RE: ST FRANCIS COLLEGE STAGE 1 - LANDSCAPING (SSD-10365)

City Plan Strategy & Development P/L (City Plan) acts on behalf of the proponent of the abovementioned application. This correspondence responds to the NSW Department of Planning, Industry & Environment's (DPIE) request for additional information in relation to the abovementioned application, dated 11 August 2020. DPIE's request also sought a response to submissions received from the public as well as other government agencies during the application's exhibition period.

- EXISTING TREES TO BE REMOVED
- EXISTING TREES TO BE RETAINED
- PROPOSED FEATURE TREE PLANTING
- PROPOSED SHRUB AND ACCENT PLANTING
- PROPOSED GROUND COVER PLANTING
- PROPOSED MATRIX PLANTING
- STAGE ONE SCOPE OF WORKS
Everything outside this scope are part of a separate approval

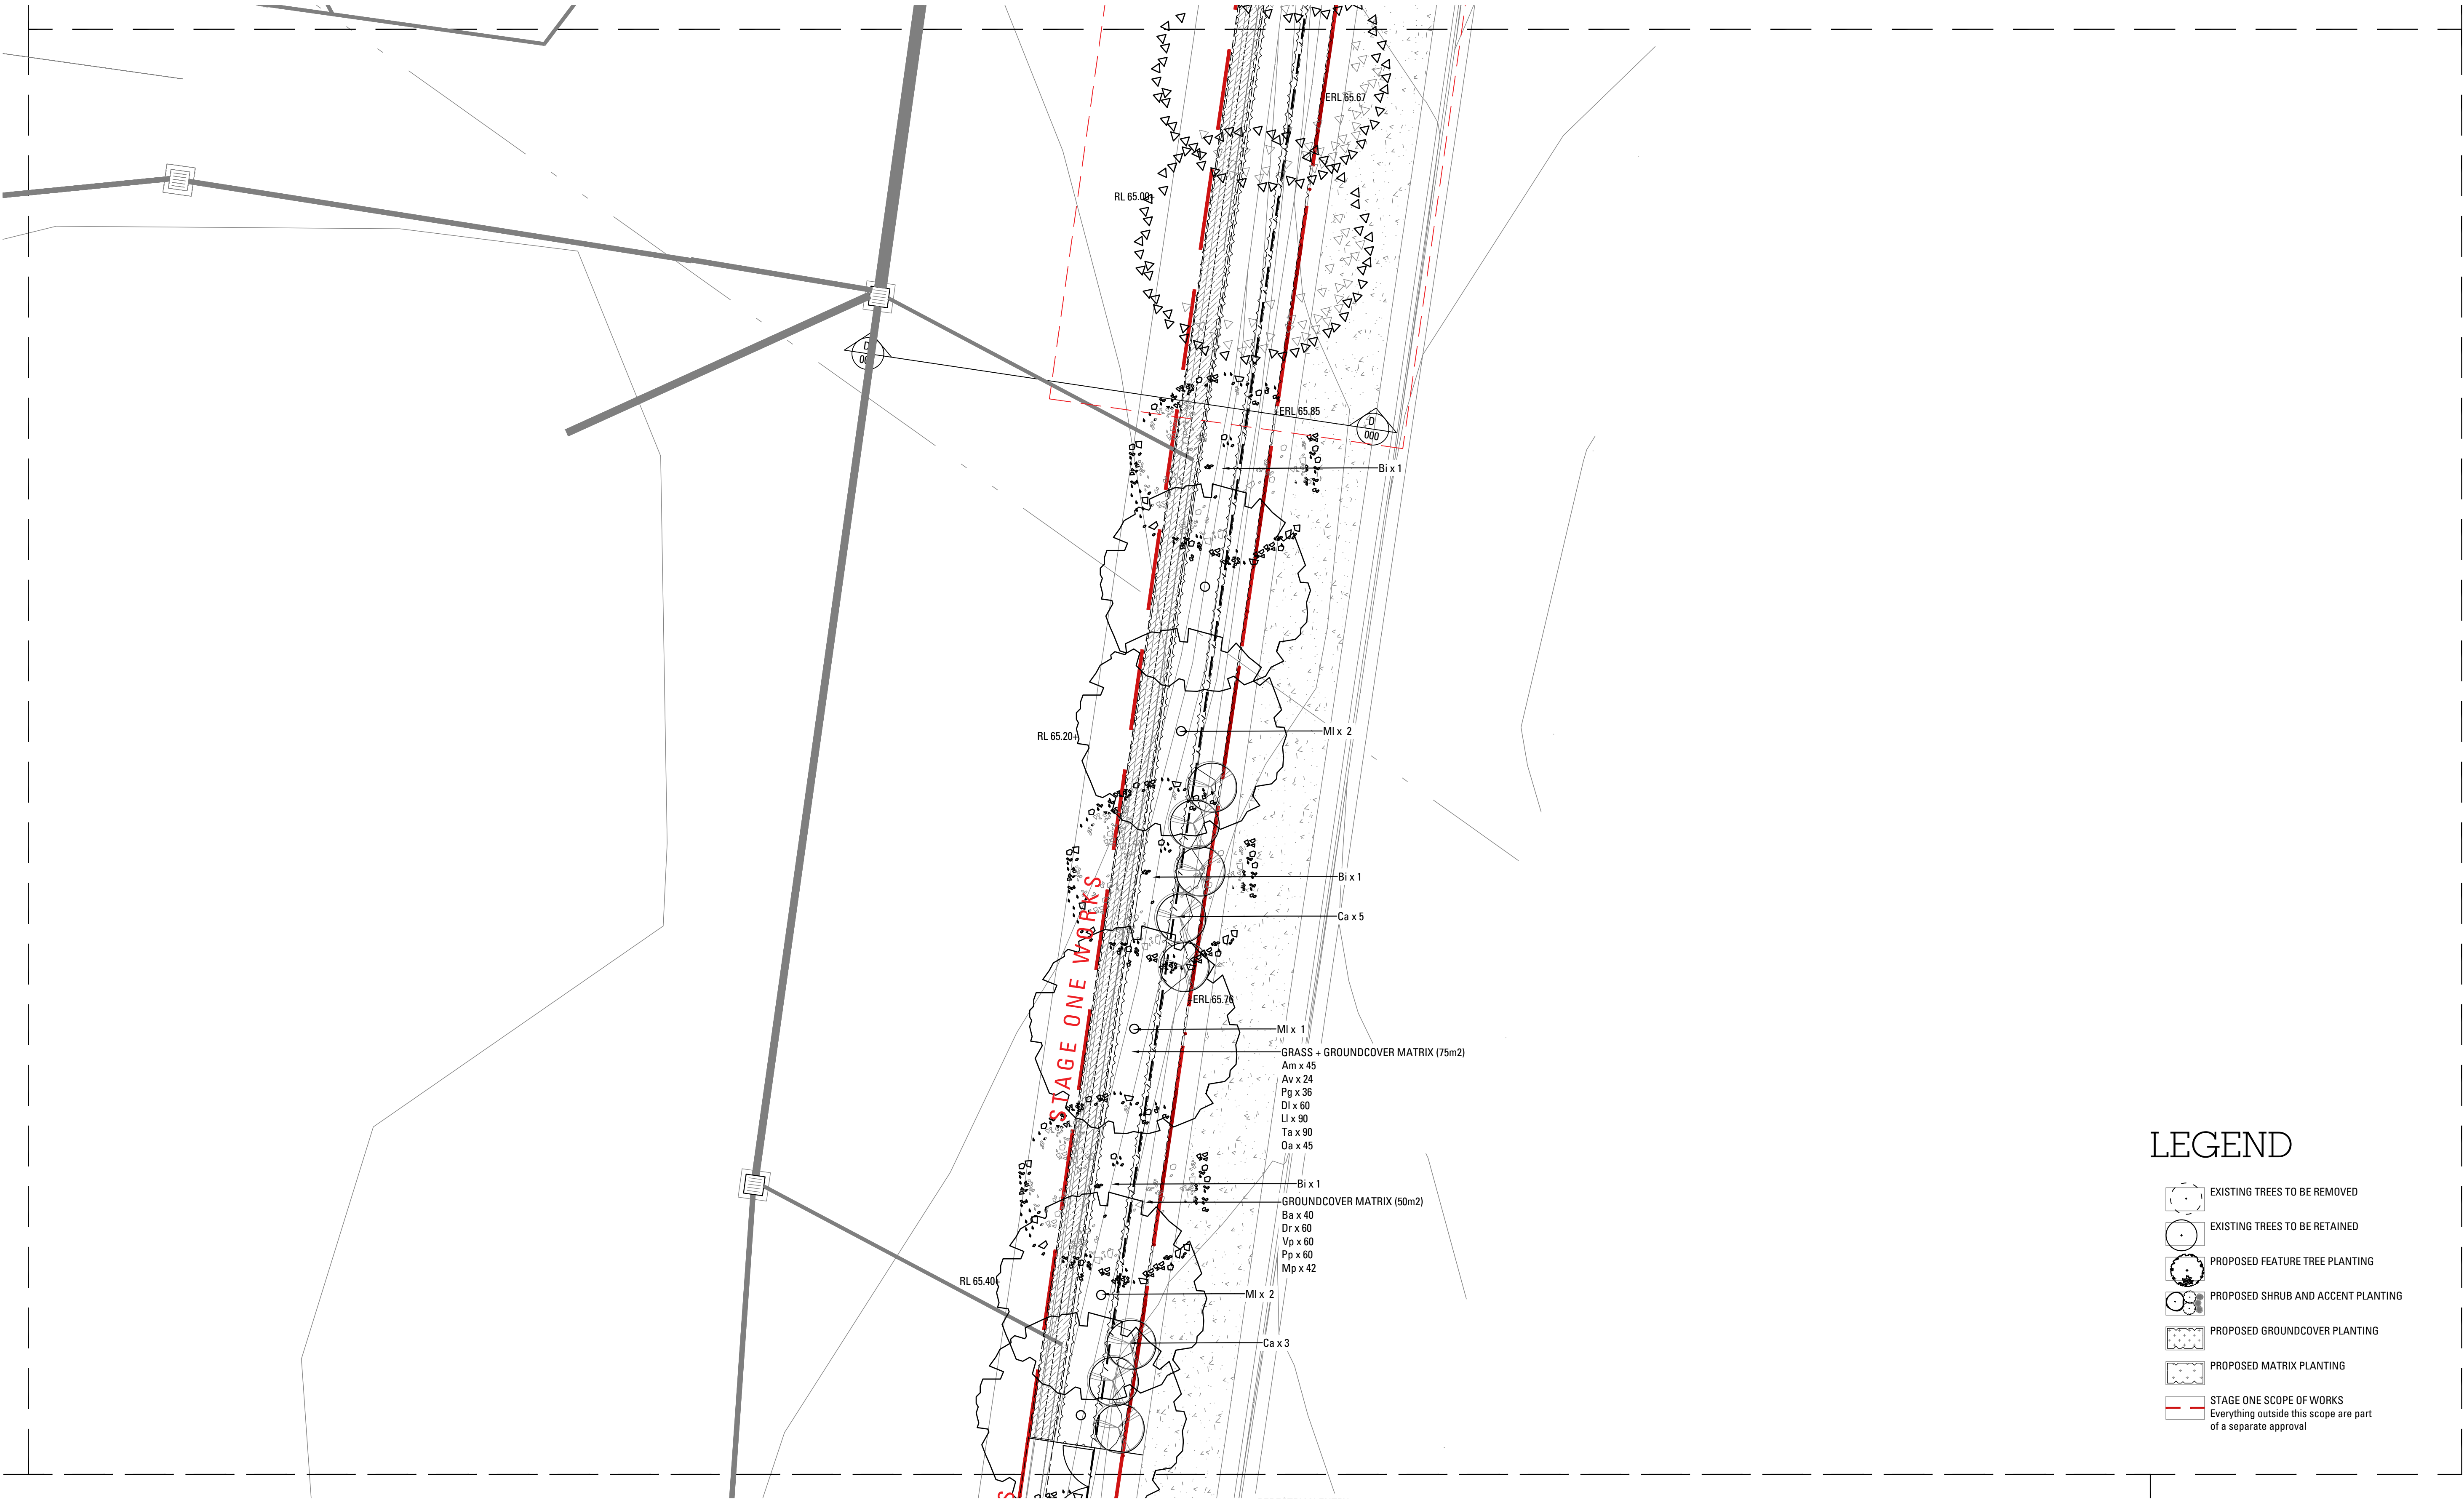
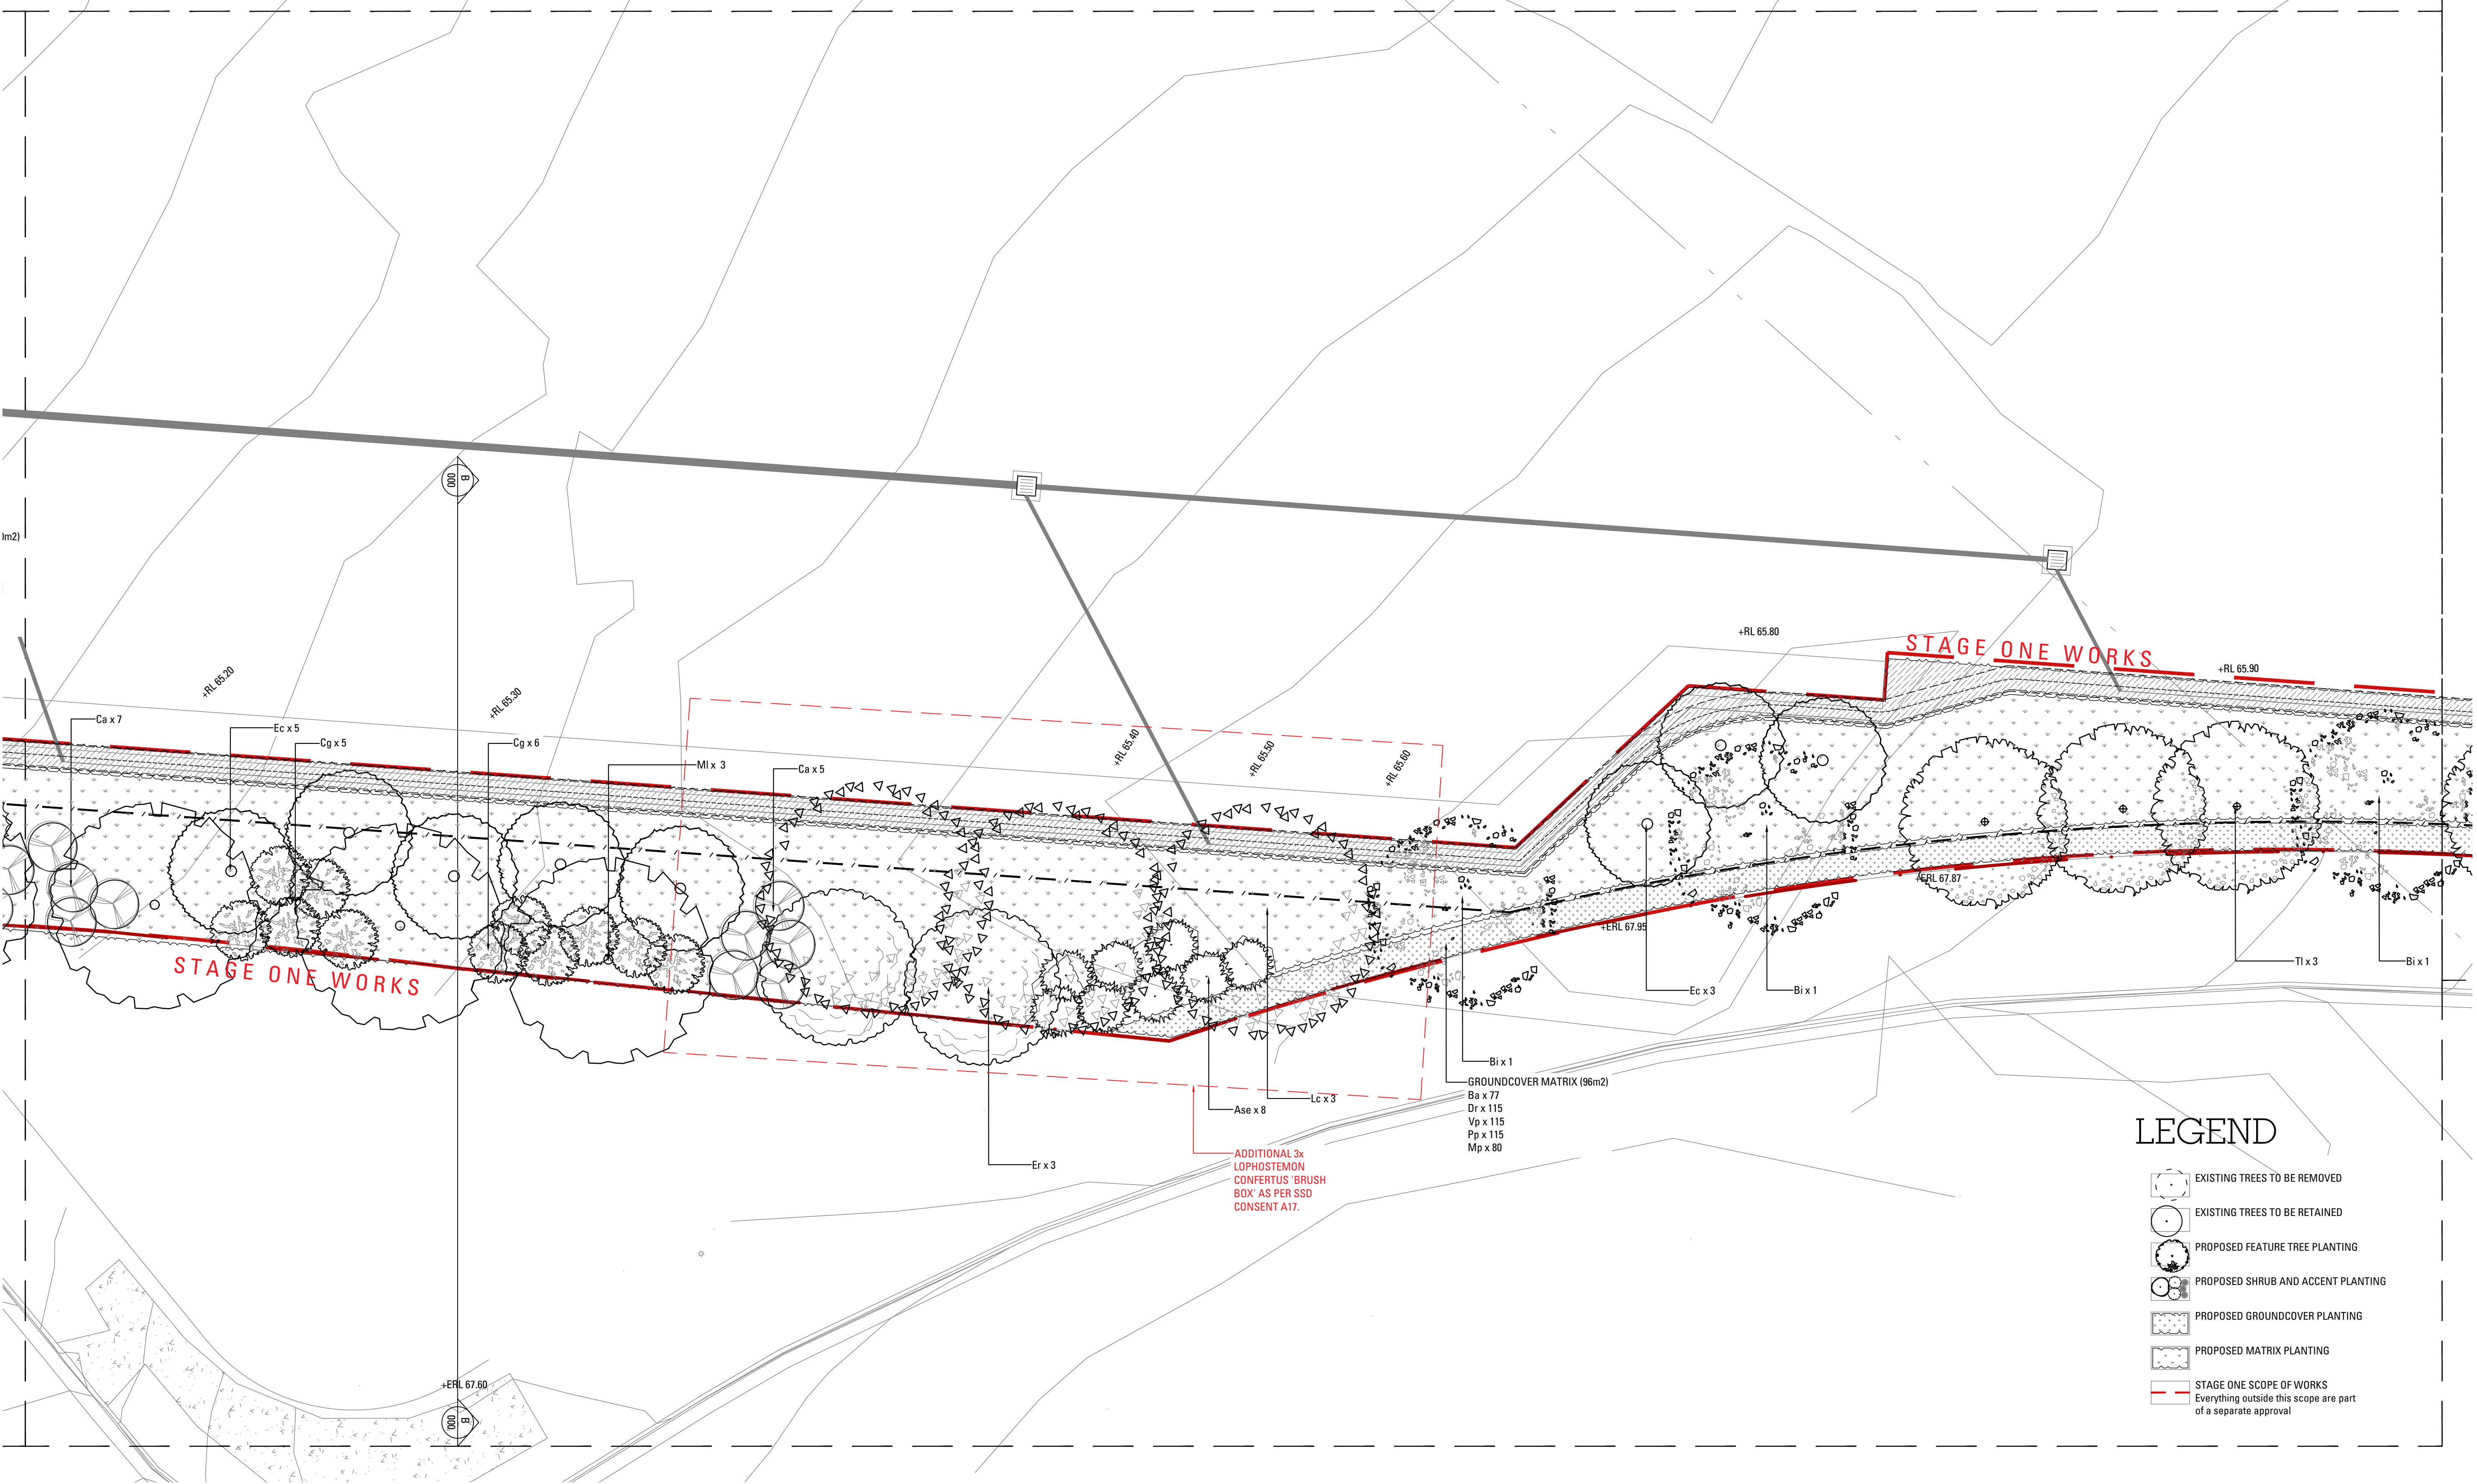
1. CLARIFICATION OF DEVELOPMENT FOOTPRINT

3. PEDESTRIAN ENTRIES

The landscape plan has been amended to include a revised legend. The legend includes a red dashed line which represents the proposed development area. A red dashed line is now clearly shown on the plan itself. The amended landscape plan accompanies this correspondence separately.

The pedestrian entries were erroneously omitted from the proposed landscape plan. An amended plan accompanies this correspondence which includes three (3) pedestrian entry points, consistent with the original Concept Approval SSD 8832. For information, an extract of the amended landscape plan showing the pedestrian entry points circled blue, is provided on the following page.
